Our Ref: FP/217/11/NMA

Application for a Non Material Amendment following a grant of planning approval FP/206/08 for the removal of the rear balcony, changes to windows and doors, change internal layout and changes to parking arrangements, 7 The Crescent, Felpham

Project Proposed plans and elevations	Sheet
Date 12th November 2011	1
Scale 1 : 100 & 1 : 50

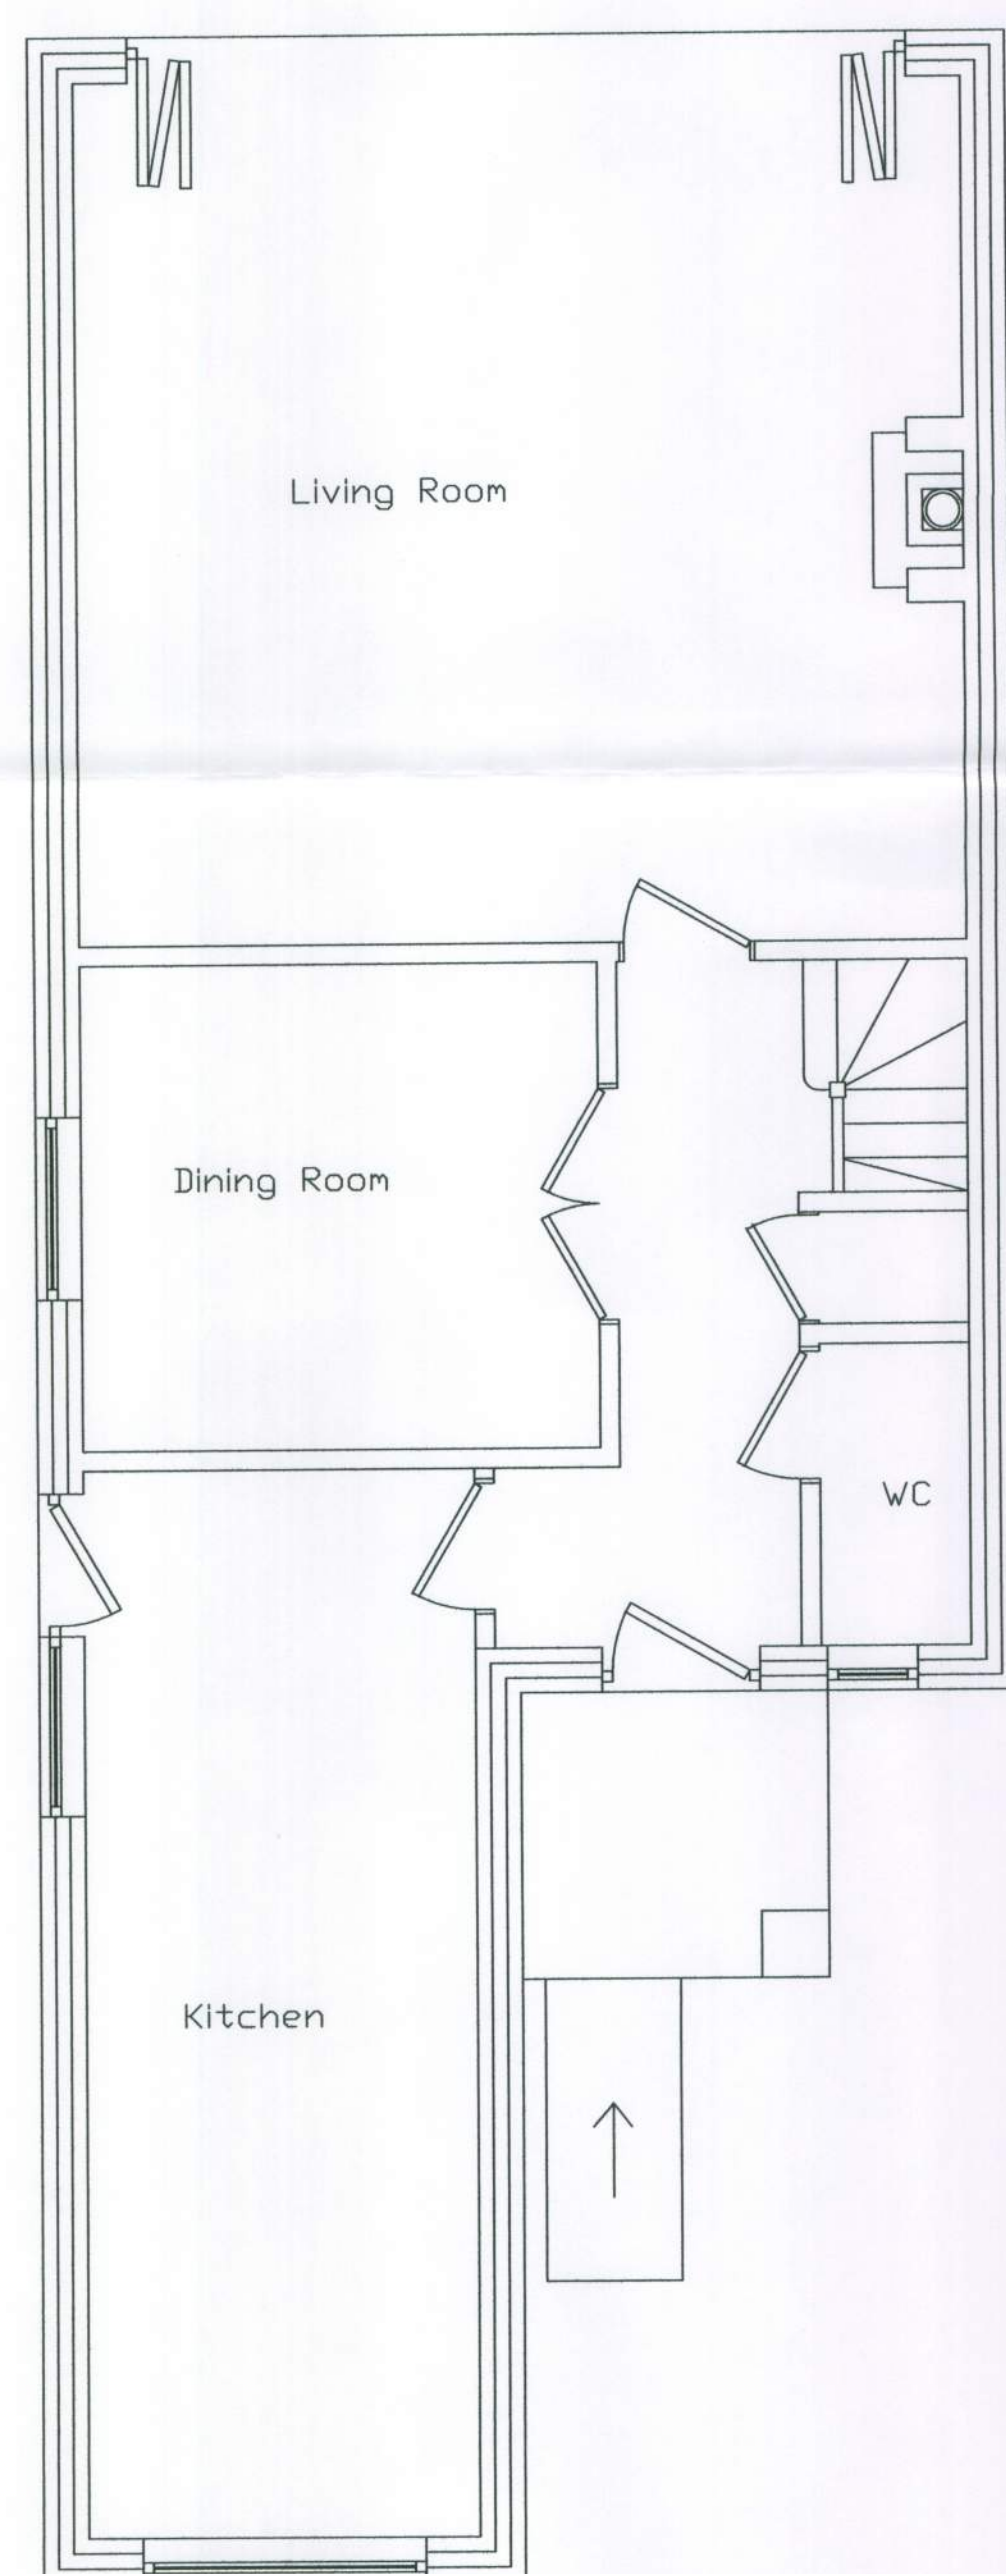
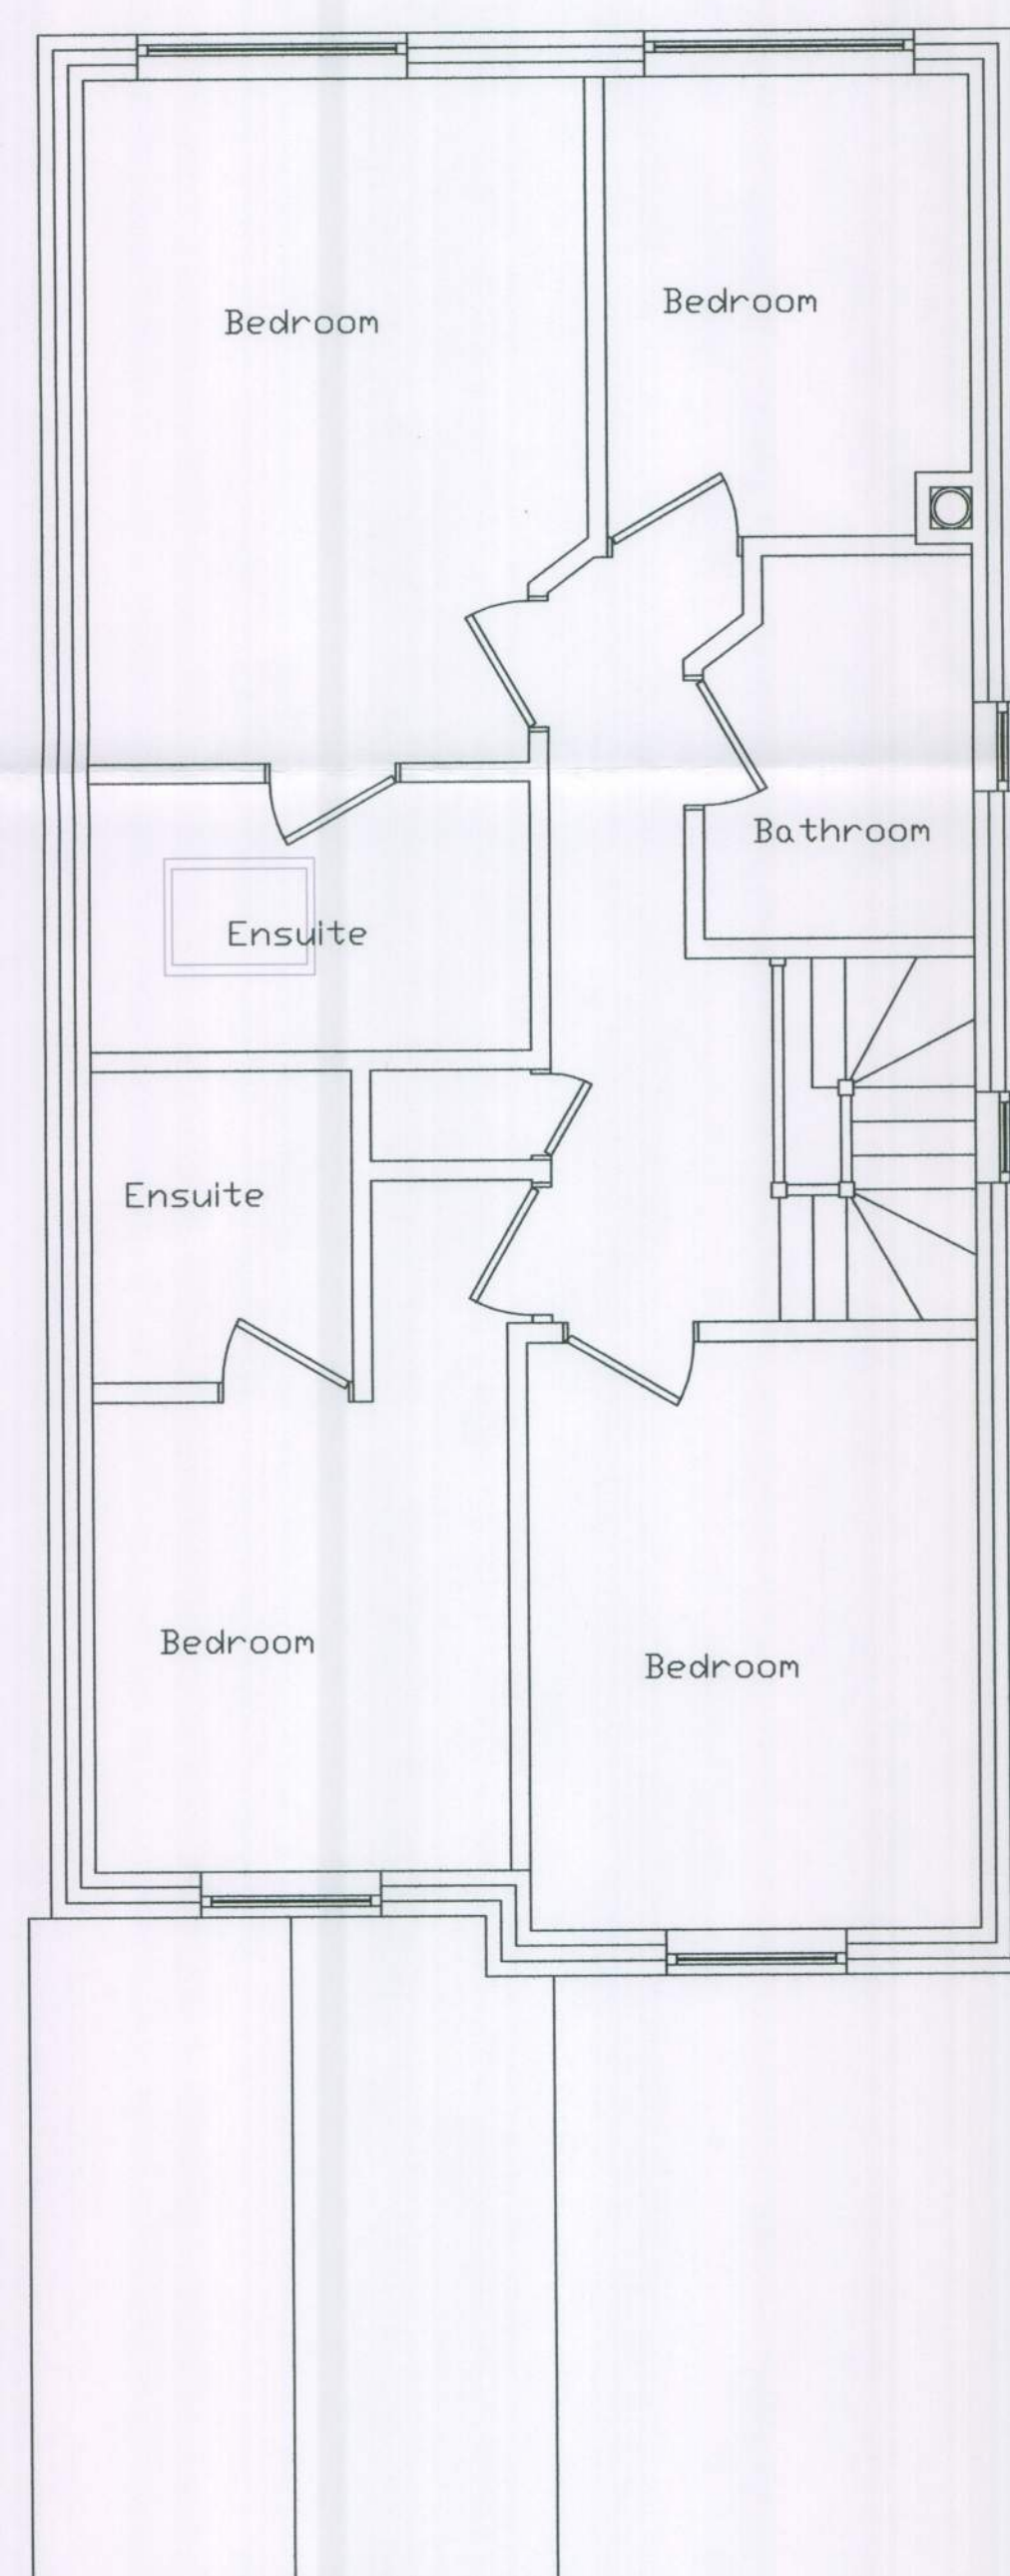
I note your proposal relates to various alterations. The change to the parking layout provision and carport and parking in the rear garden is not acceptable as a Non Material Amendment.

Should you wish to pursue this alteration, without prejudice, I would suggest a revised planning application is submitted for consideration. I would advise that I would be concerned by the introduction of parking to the rear garden without a specific justification. The carport and parking would only become permitted development once the property is occupied. In addition, should a revised application be submitted it would be subject to the requirement for a commuted sum payment in respect of affordable housing.
